Your Ref: LU/189/12/DOC

17 September 2012

Article 21 of the Town and Country Planning (General Development Procedure) Order 1995
Application for approval of details reserved by conditions 2 & 3 following a grant of planning
permission LU/180/11/L
Toddington House Toddington Lane, Wick, Littlehampton

317 / J1

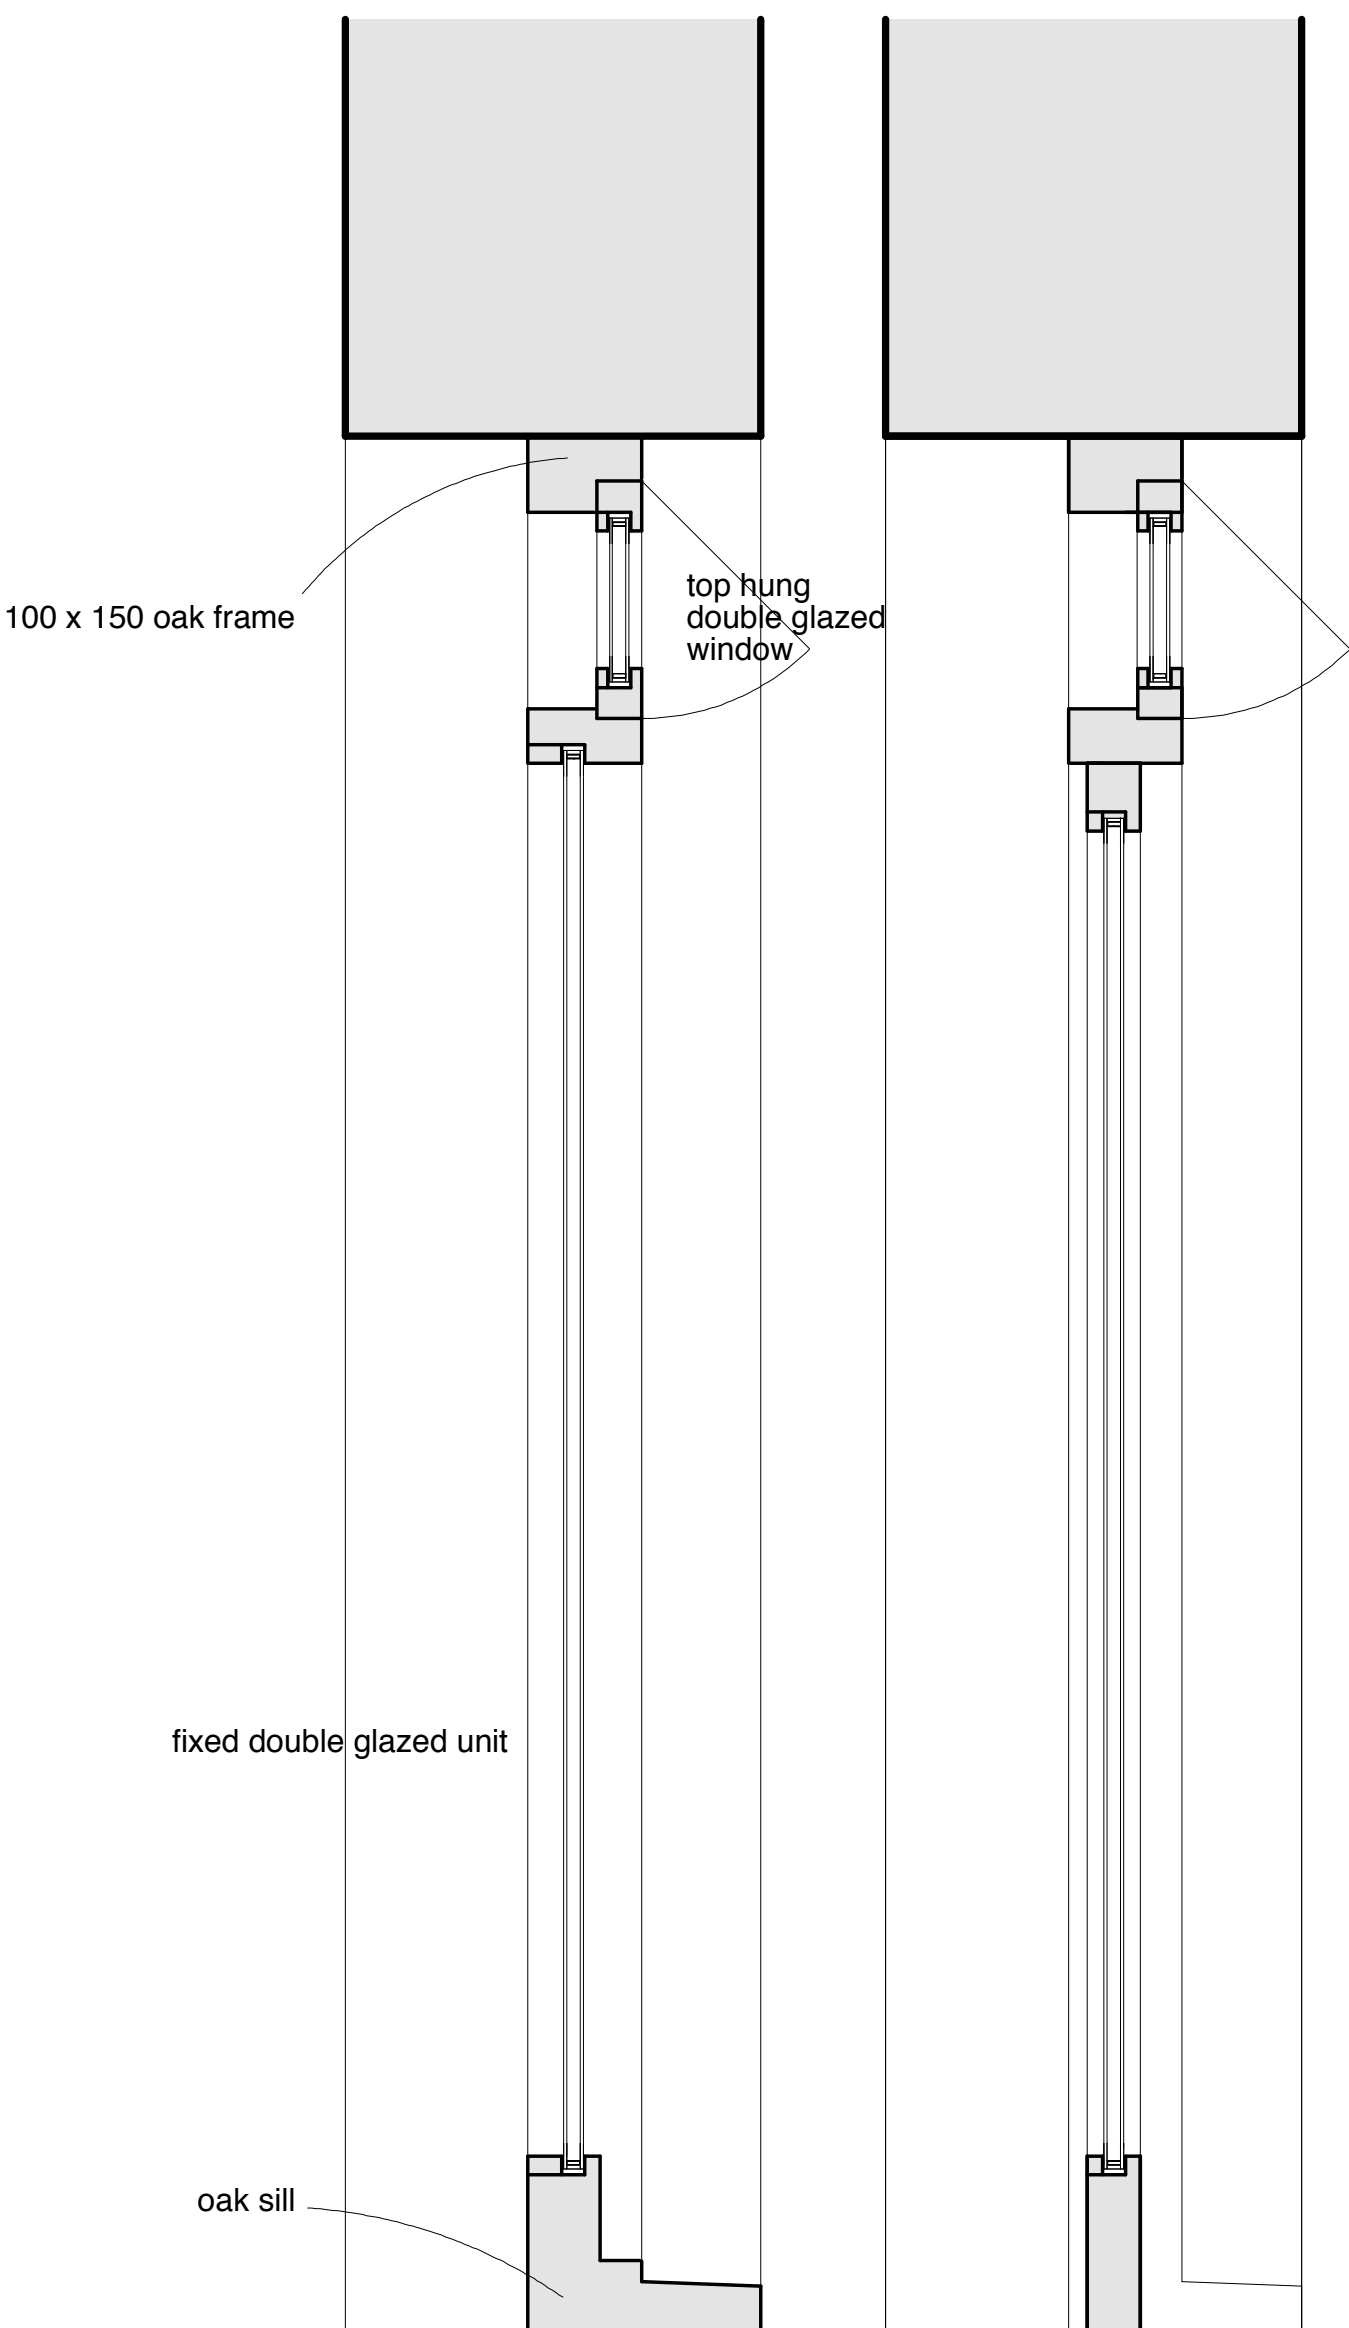
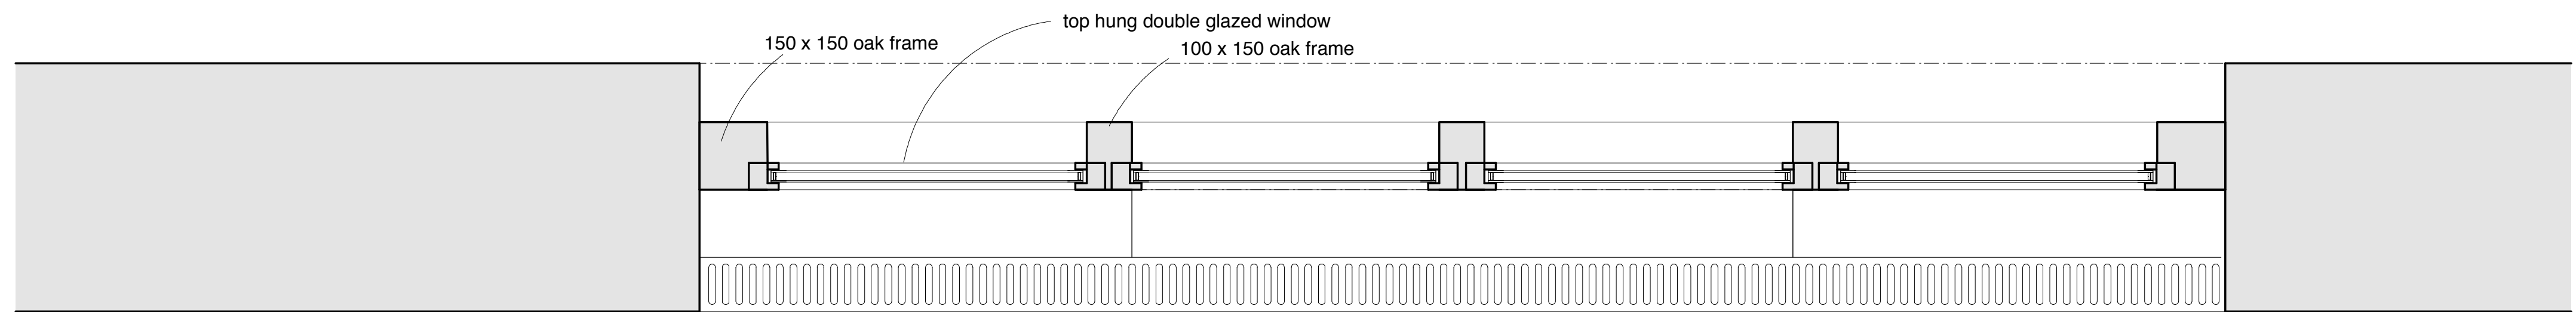
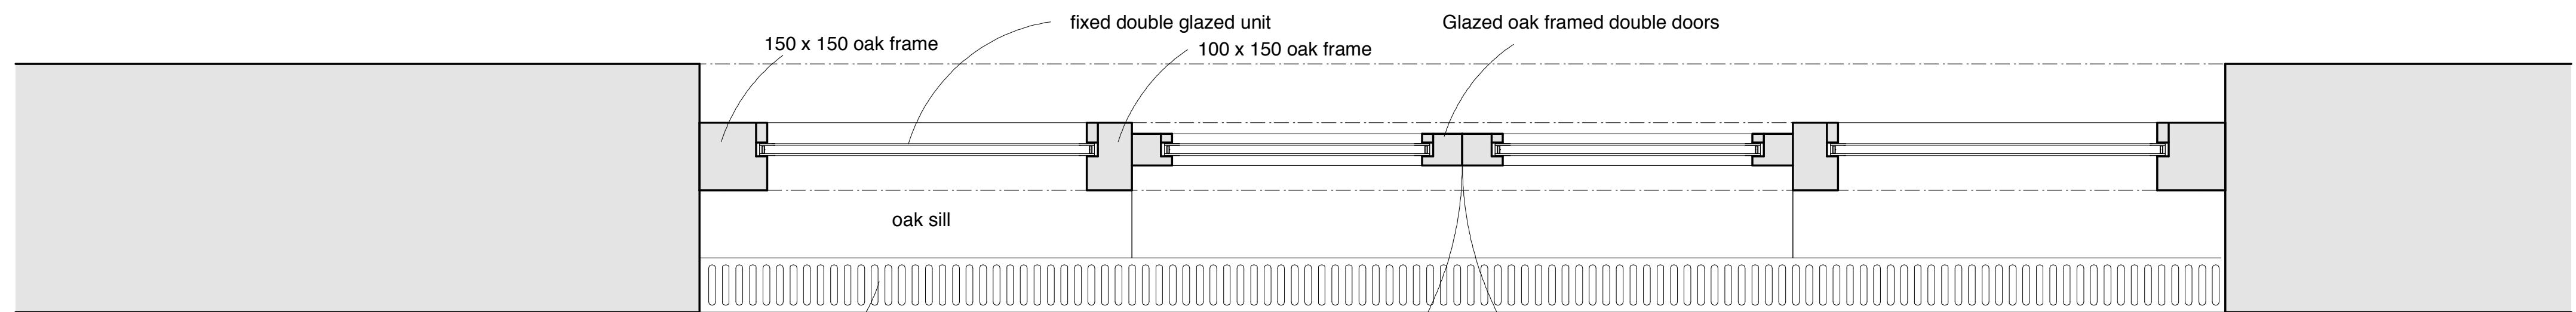
Arun District Council have decided to **APPROVE details reserved by this condition**
The proposed joinery details indicated on drawing nos. 317/J1, J2 and J4 are acceptable. The condition is therefore discharged in so far as submission of details relates.
